Antony Witherdin
 Director – Key Sites Assessment – DPIE
 City of Sydney
 456 Kent Street, Sydney
 NSW 2000

City of Sydney Review Response- Waterloo Metro Quarter

It is understood that after submission of the planning documents for the Waterloo Metro Quarter Development, commentary has been provided on the submission. The comments received are noted below, with commentary in response discussed in this letter. This document is an addendum to the submitted Appendix JJ – Northern Precinct Landscape Design Report.

Deep Soil

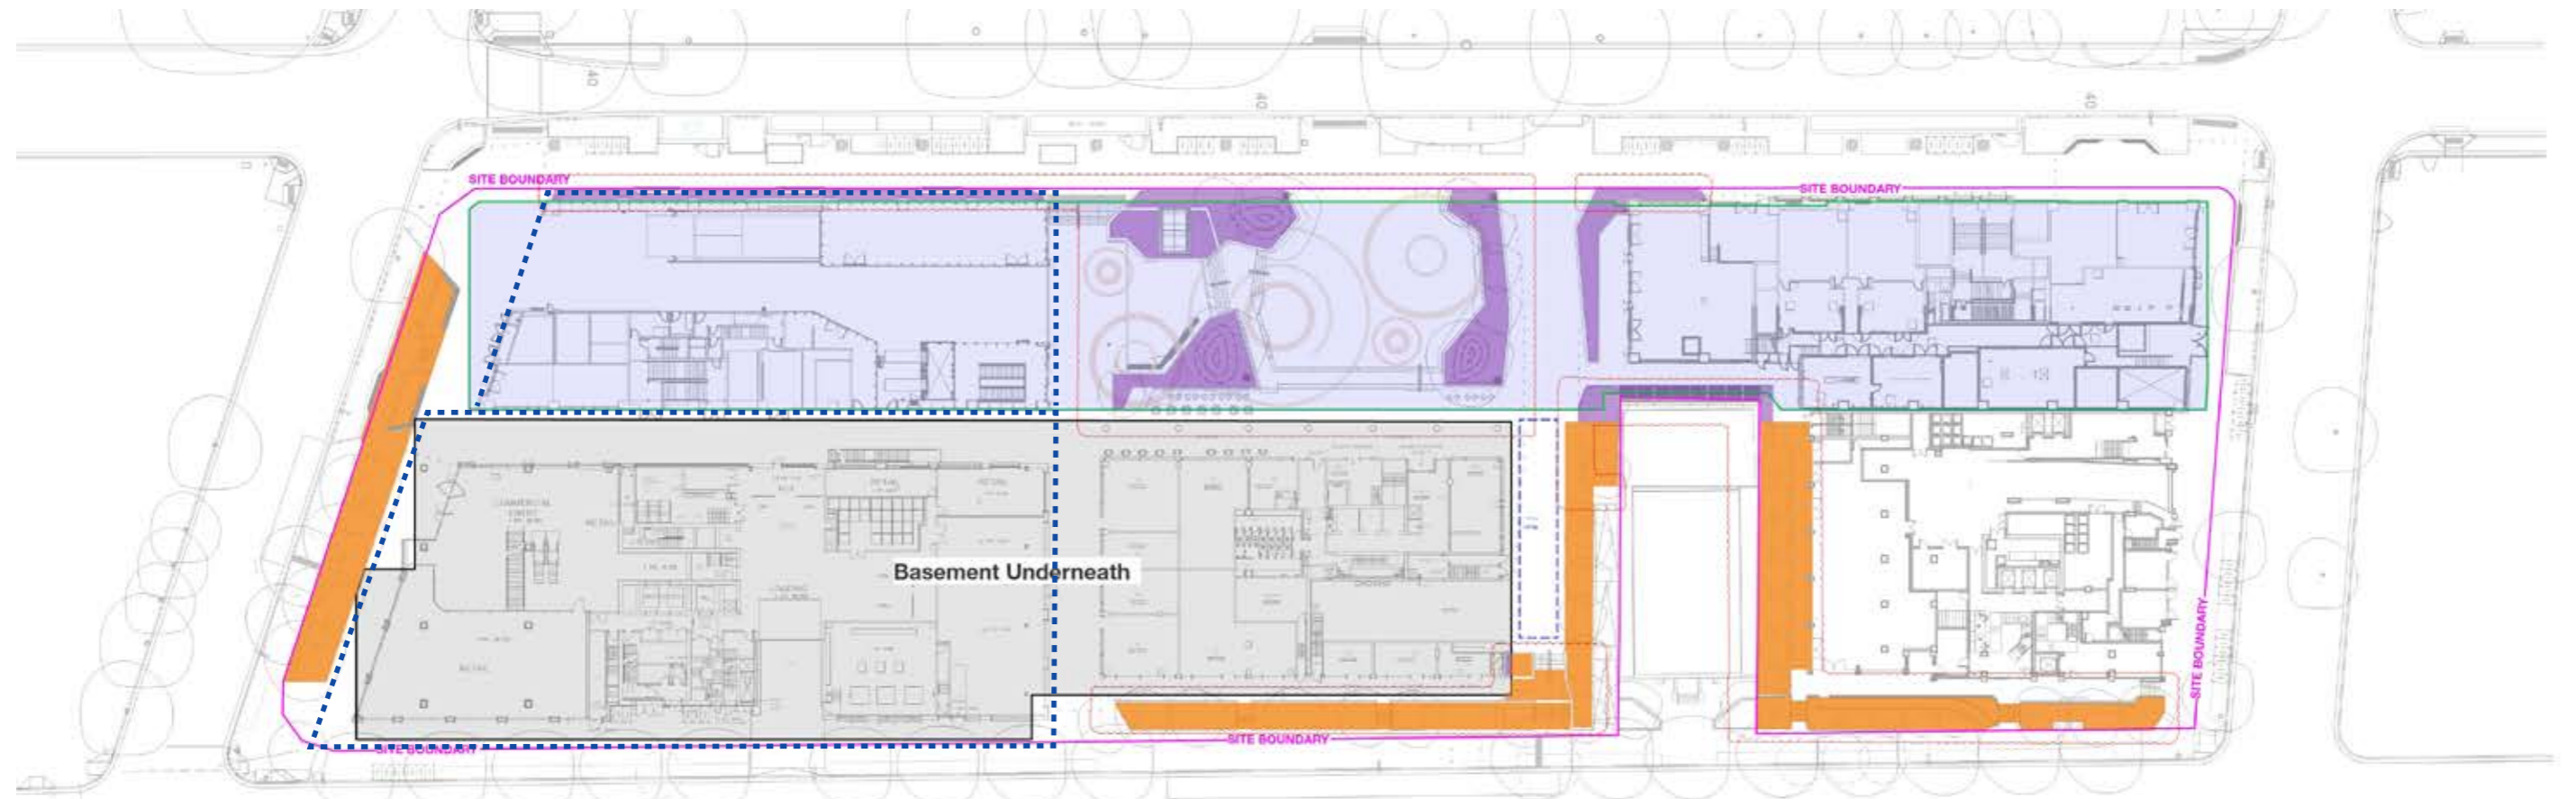
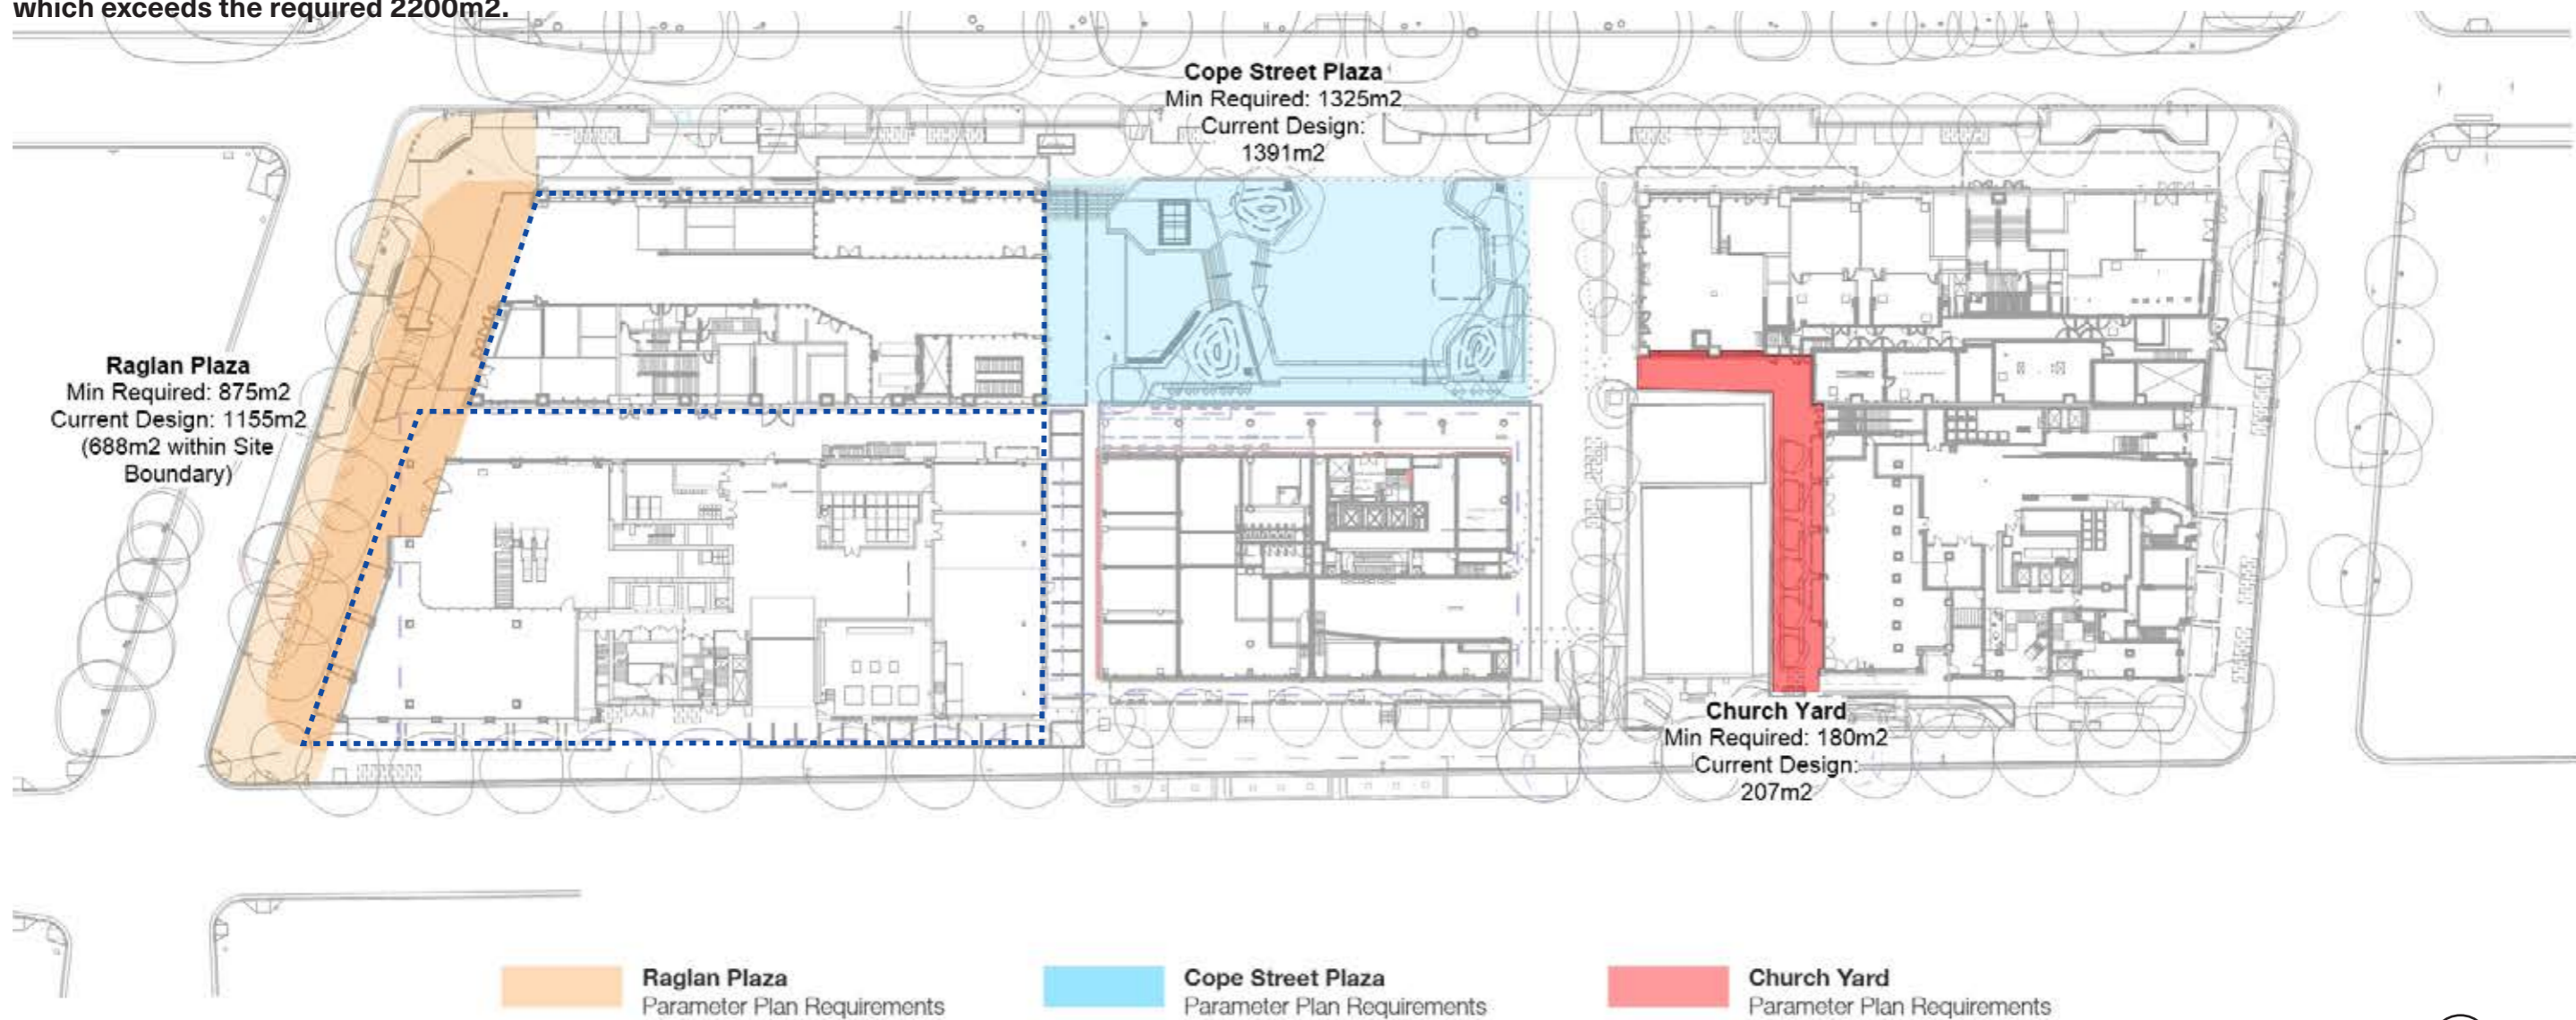
Landscaping (continued)		
38	<p><i>Deep soil – Deep soil is underprovided, equating to approximately half of the area claimed. The Sydney Development Control Plan 2012 (SDCP) and ADG both have a minimum deep soil dimension of three metres. Many of the proposed garden beds are less than this three metre minimum and it is noteworthy that the remaining quantity of compliant deep soil relies heavily on permeable paving. City staff calculate that approximately 470sqm or 5.7% of the site area is allocated to deep soil.</i></p>	<p>Deep soil areas have been amended and the calculations now only include soil areas with a minimum width of 3m. This includes a 3m wide deep soil area to the Botany Road frontage, removing raised planter retaining walls and providing a continuous planting area with steps bridging this space and permeable surfacing to the cantilevered ramp. The deep soil area allocated to the site now measures 10.4%.</p> <p>Refer to Northern Precinct Landscape Design Report page 15 'Deep Soil'.</p>

NORTHERN PRECINCT | LANDSCAPE PLAN

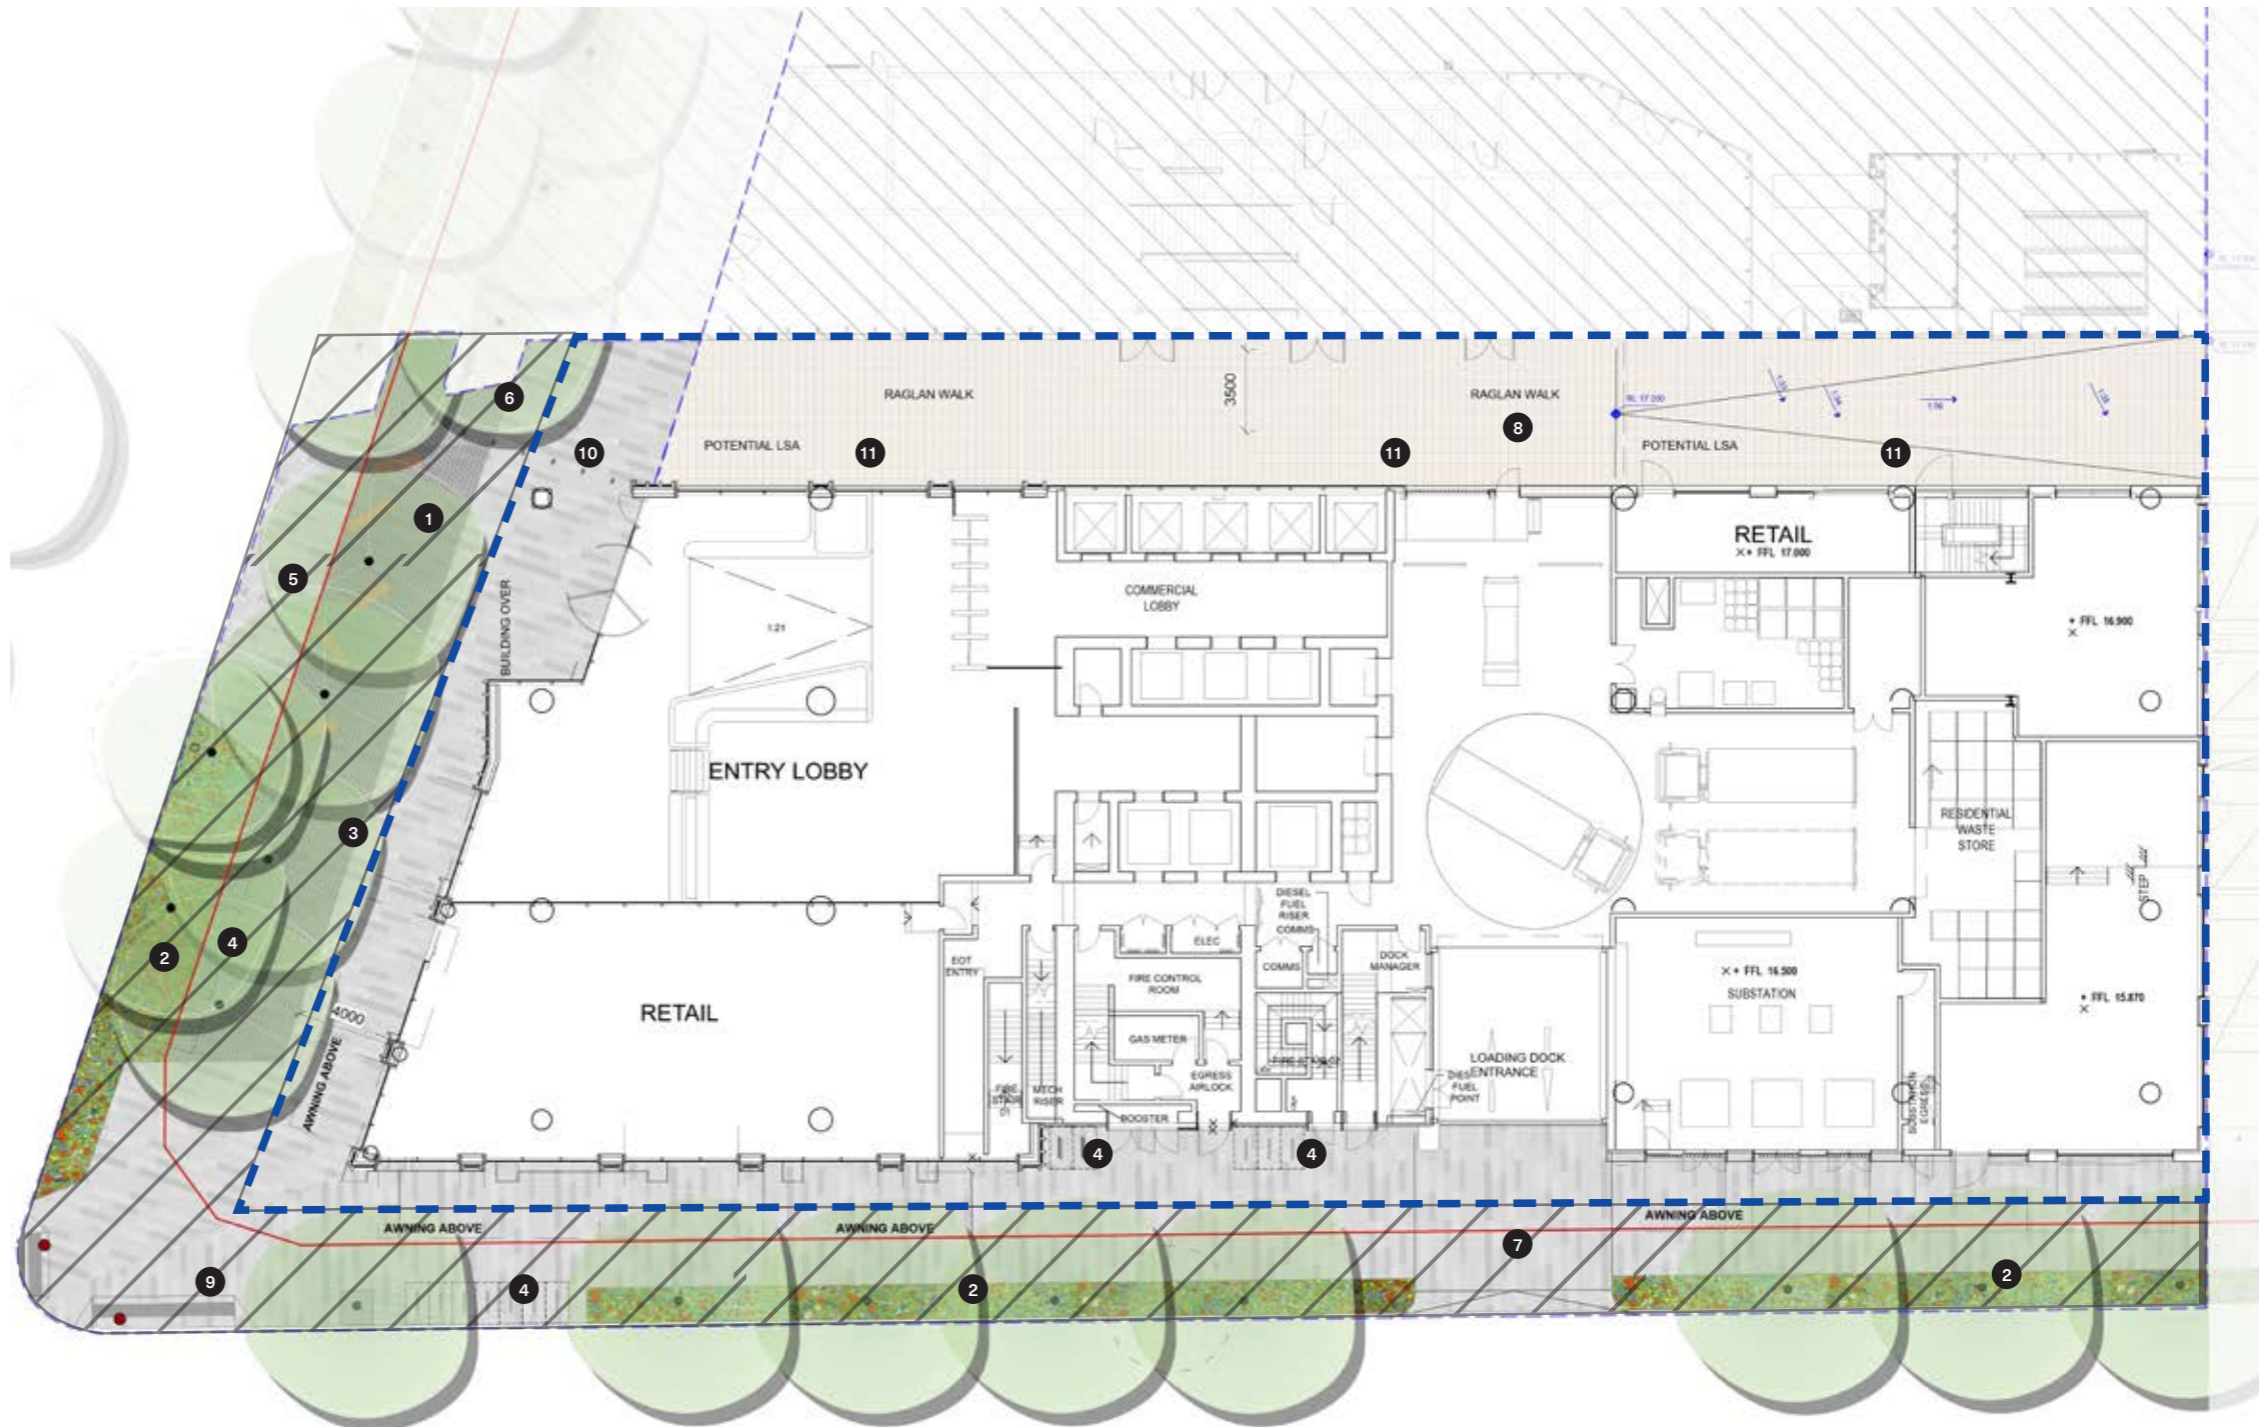
39	<p><i>Bollards - The use of bollards, presumably for security reasons, is awkward and excessive. This is consistent with advice provided regarding the CSSI application. To the Cope Street Plaza and the shared surface, bollards are spaced 1.2 metres apart and often directly adjacent to an alternative 'barrier' such as a raised planter or steps. Not only is the duplication of barriers unnecessary, but the 1.2 metres spacing may be prohibitive to wheelchair users who can just get through such a gap. Please remove bollards where they are unnecessary, such as in front of a natural barrier like stairs or a raised planter and increase the spacing of bollards to a more comfortable 1.5 metres.</i></p>	<p>The bollards are required for Hostile Vehicle Mitigation (HVM) and are spaced 1200mm between the outside faces of the bollards.</p> <p>Typical occupied widths of wheelchairs is 800mm therefore the bollard spacing allows for sufficient wheelchair access.</p> <p>Bollards have only been placed where required to meet the HVM requirements as stipulated by Sydney Metro on Raglan Street.</p>
